**Lancashire
Constabulary**

22nd April 2014

**Planning Application 3/2014/0300 Outline Application for 28No.
dwellings at land off Mill Lane, Gisburn**

PROPOSED SITE PLAN	
Site: Proposed Development Land off Mill Lane Gisburn	320140300?
Client: Mr Guy Hindley	
Date: 31-3-2014	Scale: 1:1000 @ A1
Project No: J348-Access-Flg1	Drawn: AD
Amendments:

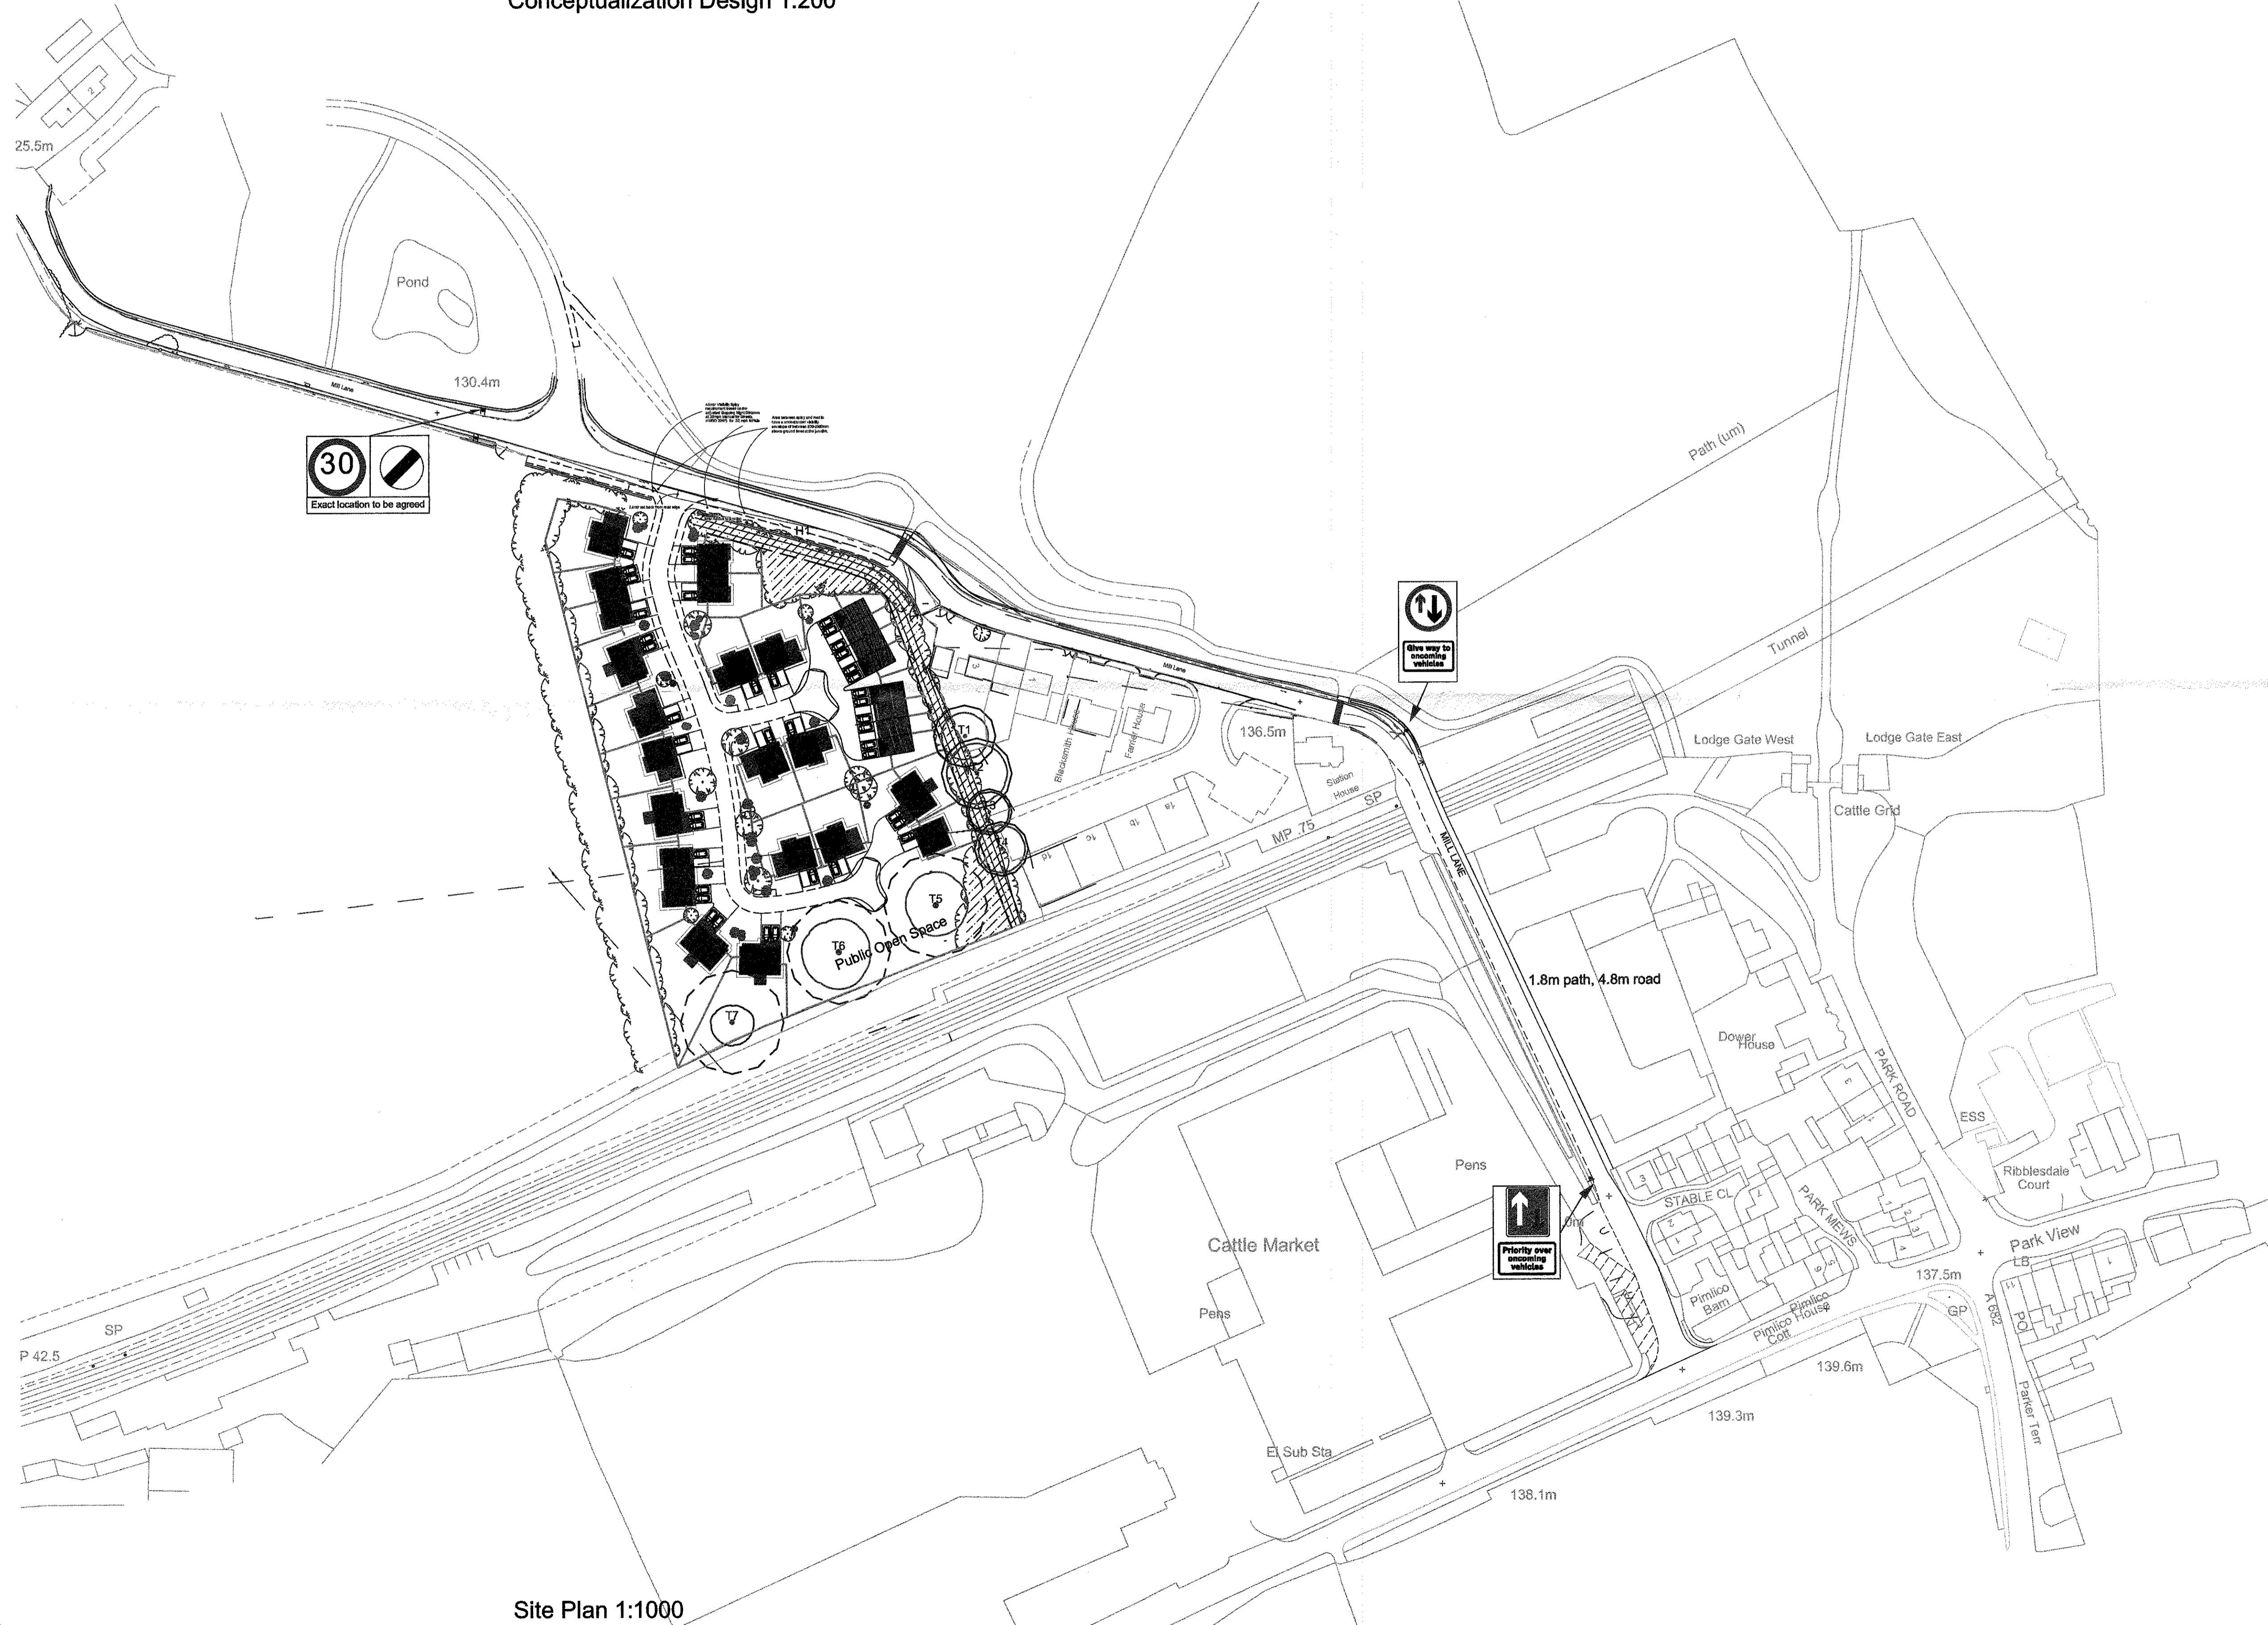
The cul de sac arrangement and differing orientation of dwellings allows good natural surveillance around the development. The layout also discourages casual intruders from looking for opportunist crimes as they are more likely to stand out and be observed or challenged.

Where possible the gardens are arranged in a back to back layout which helps to reduce the risk of burglary.

In curtilage parking is provided for all dwellings which helps to reduce the risk of auto-crime.

Where rear/side gardens abut open space, industrial areas or other areas where access to the boundary treatment would be unrestricted or concealed, the boundary treatment must be a minimum height of 1.8m and robust in nature such as close boarded fencing or similar. This is essential to reduce the risk of crime to these vulnerable areas.
